STATE OF NORTH CAROLINA
DEPARTMENT OF TRANSPORTATION

Subject: Request for Permit Modification and Extension to Section 404 Individual Permit and Section 401 Water Quality Certification for the proposed improvements to NC 3 (Mooresville Road), Kannapolis Parkway to Dale Earnhardt Boulevard/Loop Road (SR 1691), Kannapolis in Cabarrus County; Division 10, **TIP No. U-3440**.
Debit \$570 from WBS 39010.1.R2.

The purpose of this letter is to request a modification and extension to the United States Army Corps of Engineers (USACE) Section 404 Individual Permit and associated North Carolina Division of Water Resources (NCDWR) Section 401 Water Quality Certification for the above referenced project.

Drawing file: 100 Roadway Plans / 100_137_U3440_RDY_FP_PSH_12.pdf

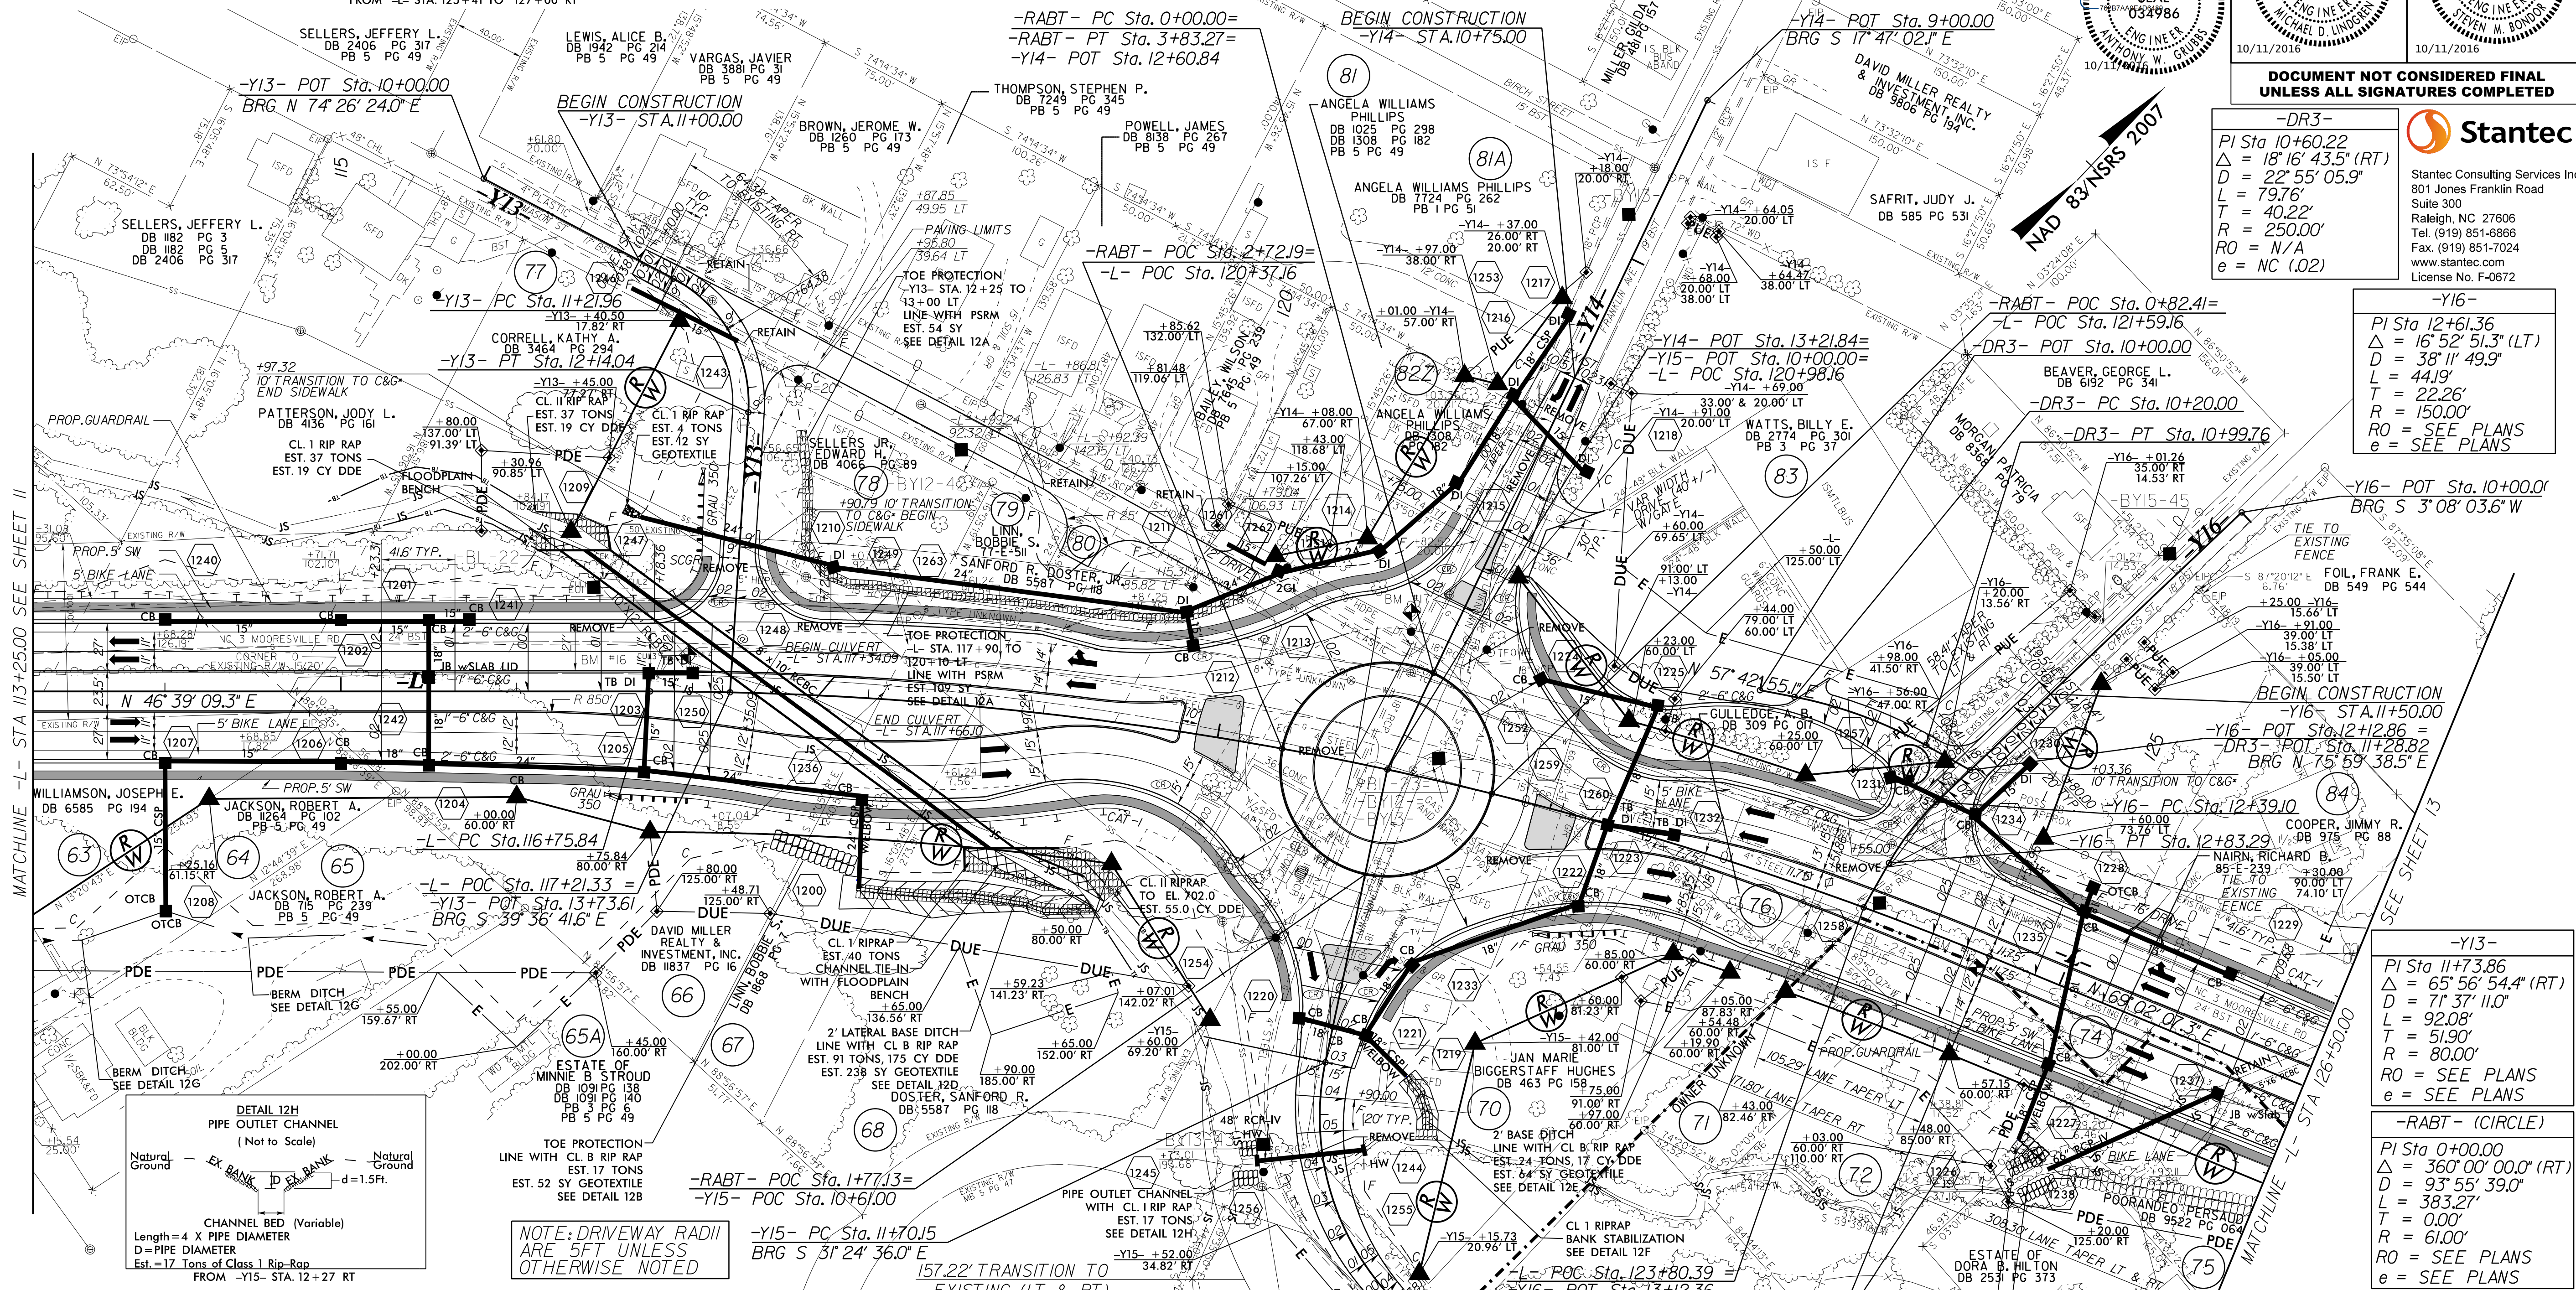
During an agency site visit to Site 6 (a culvert replacement and extension to an UT to Irish Buffalo Creek) it was noted that this stream has shifted into the roadway fill slope and was not in the location as depicted in the permitted drawings.

This modification reflects the current location of the stream, and presents a design that is intended to stabilize this sandy system to ensure roadway fill slope stability.

As depicted on the attached revised Site 6, (Plan sheet 12) hydraulic designers have retained the previously permitted bank stabilization near the outlet of the culvert but have added 80 linear feet of channel relocation where the stream currently turns back into the roadway slope. A 7-10' floodplain bench will be re-established. The adjacent roadway fill slope will be armored as a "Hardened Fill Slope" for protection during high flow events.
